MEMORANDUM

Subject: Application ID: 2017-289

Date: 1/18/2018

[ Visitors Garage ] Logistics Plans and Studies

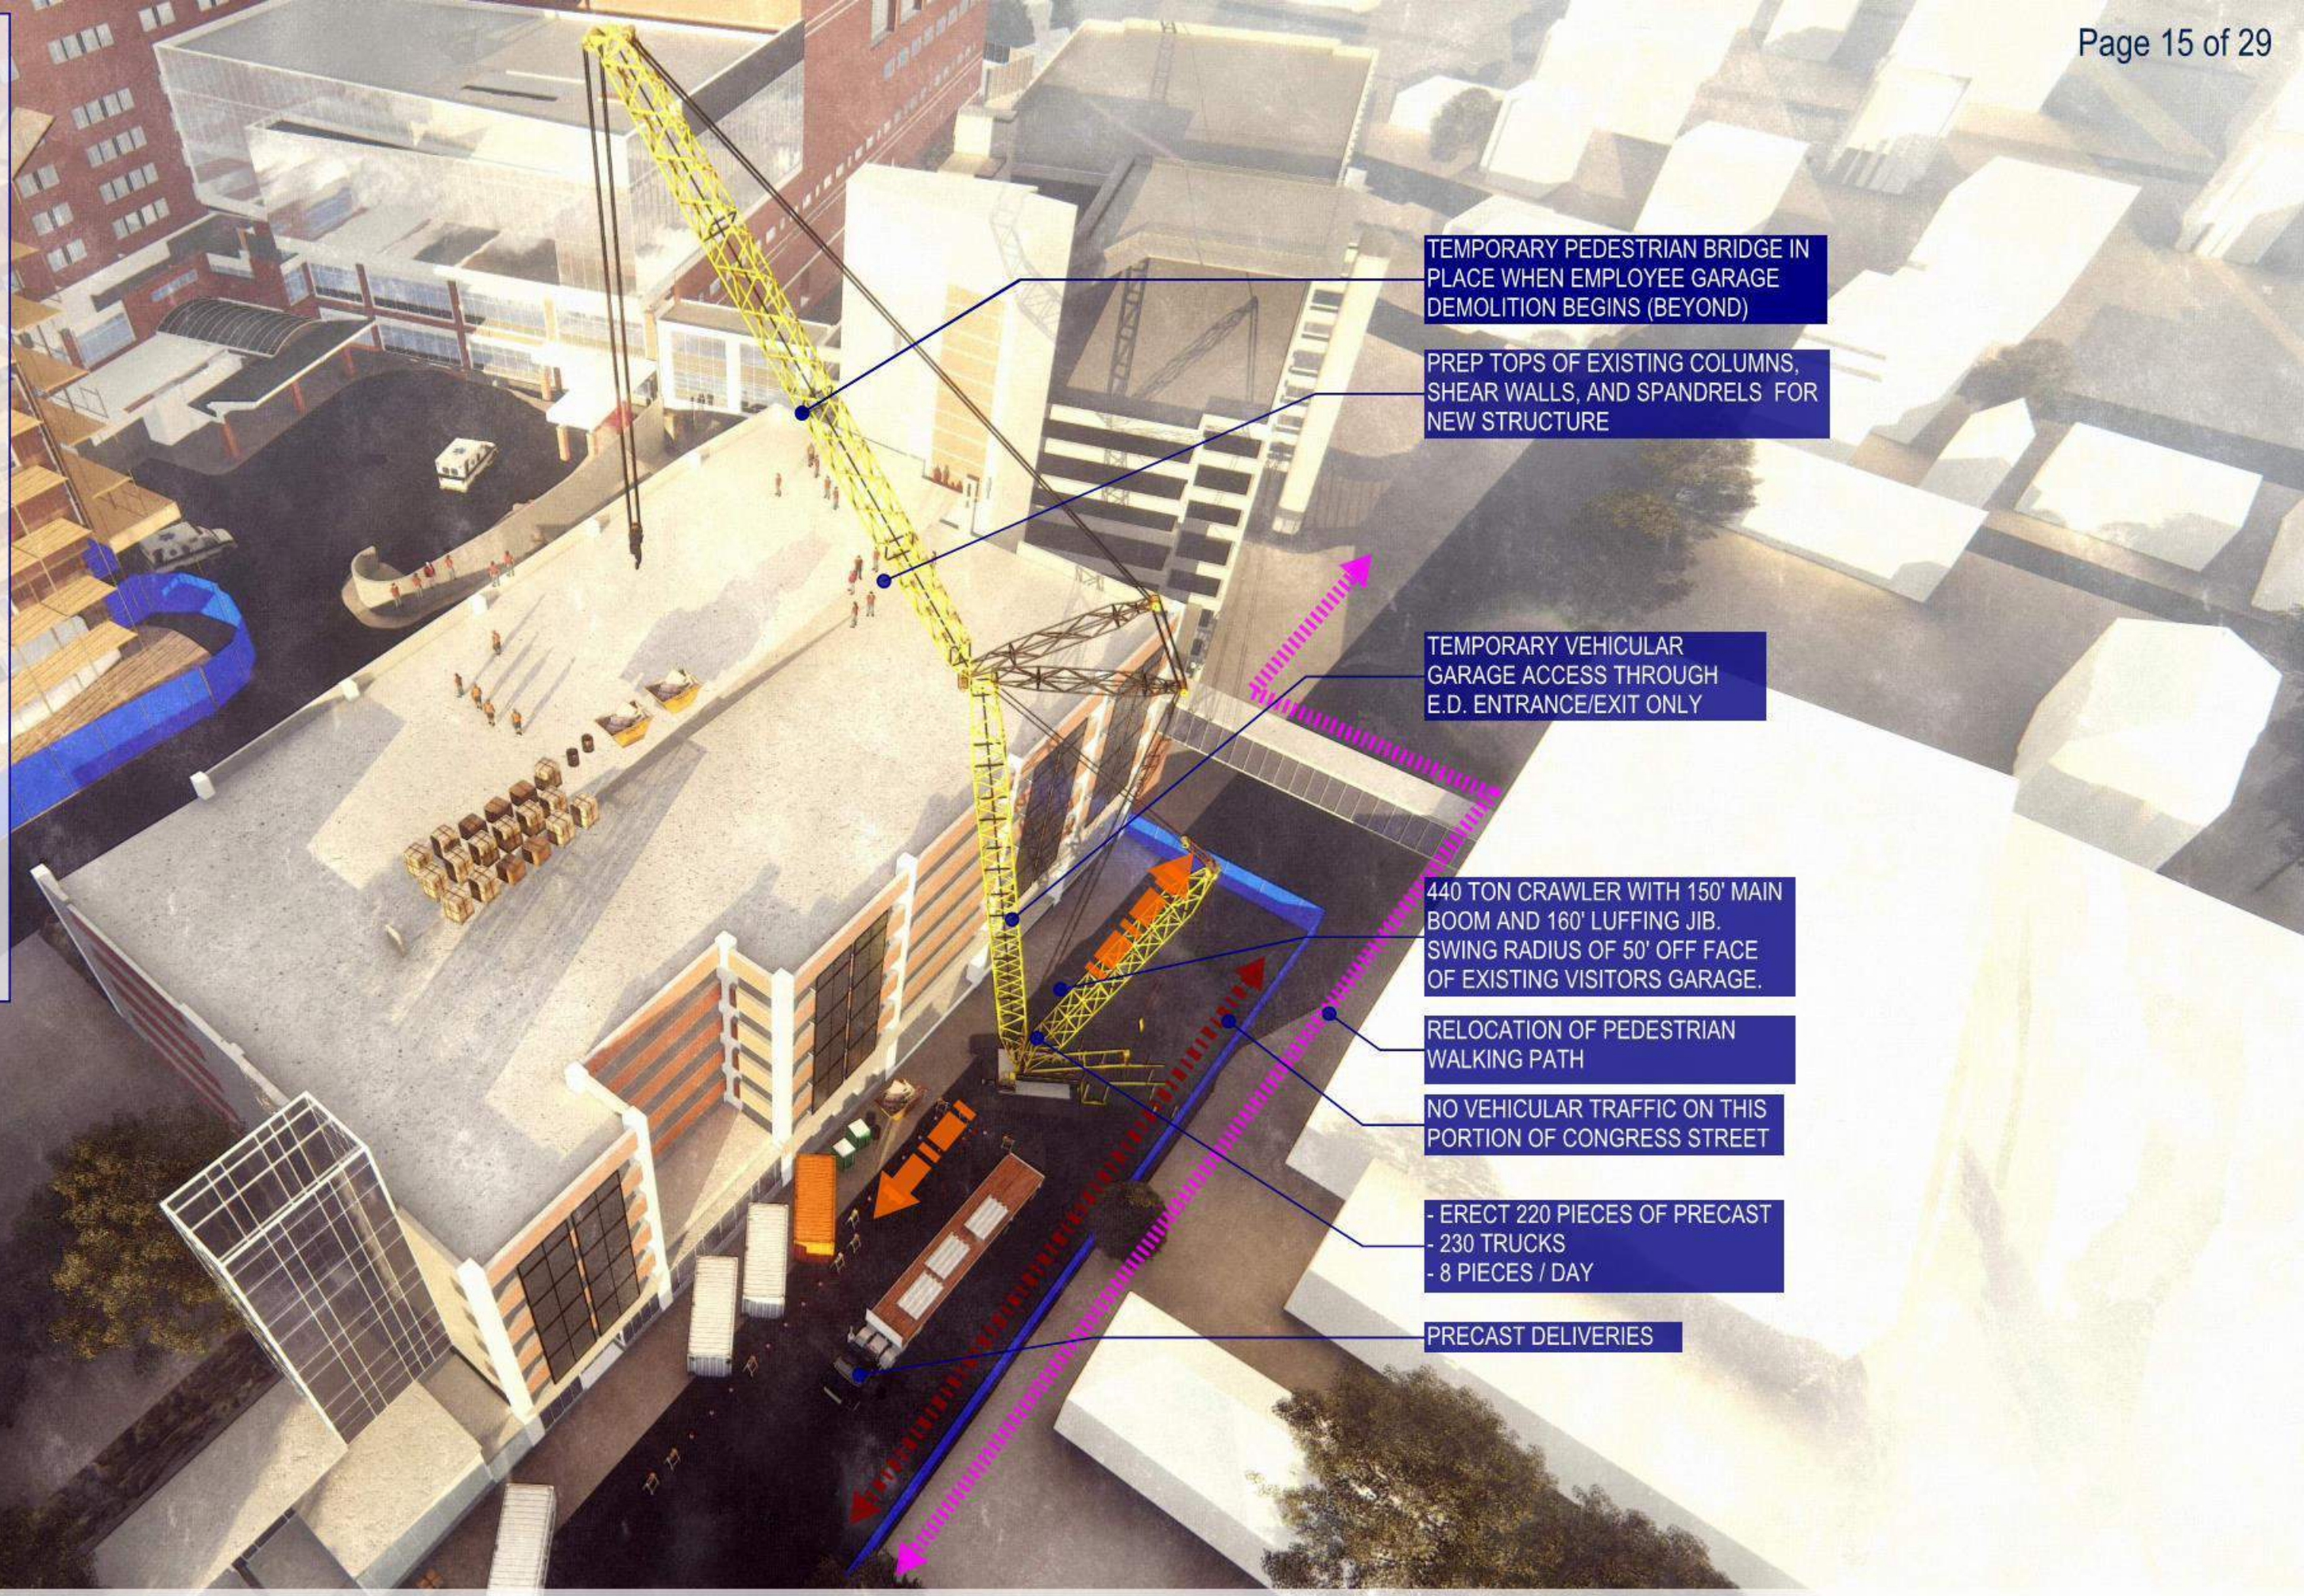
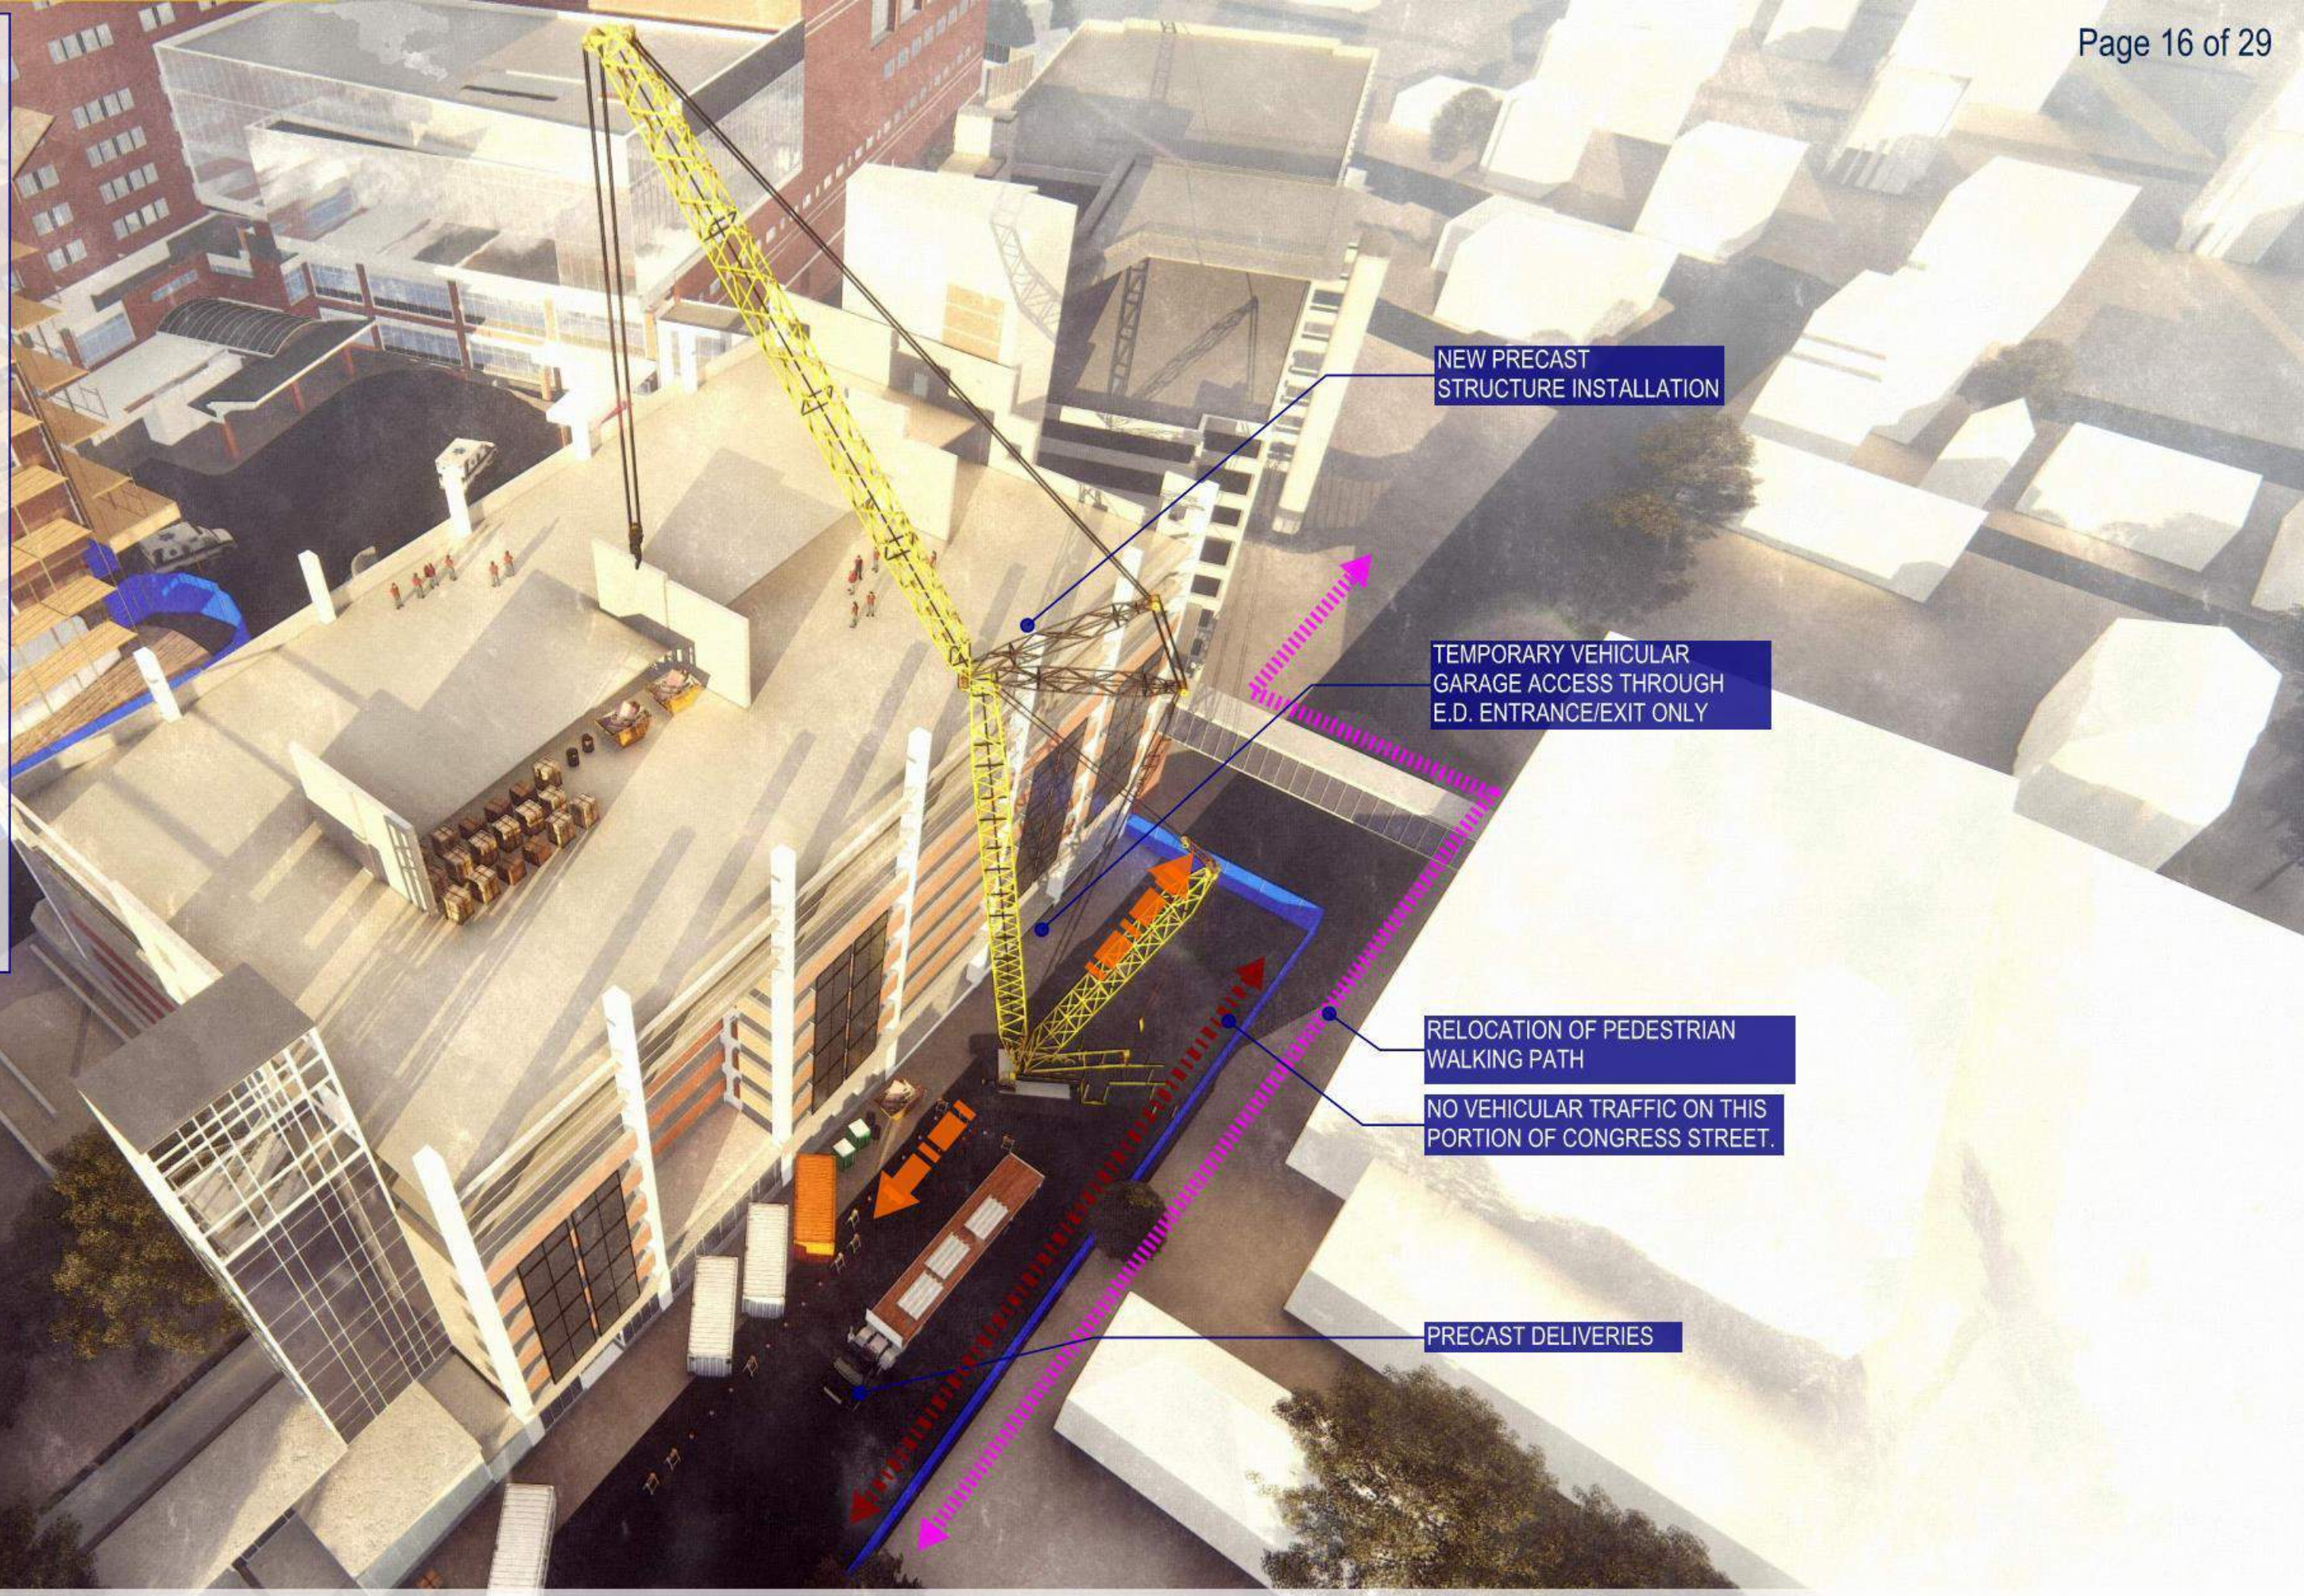
The Fire Dept is opposed to the closing of Congress Street, doing so will create difficulty for all ambulances in getting their patients to the hospital emergency room. The proposed detours will create high congestion on all streets leading to the hospital emergency department.
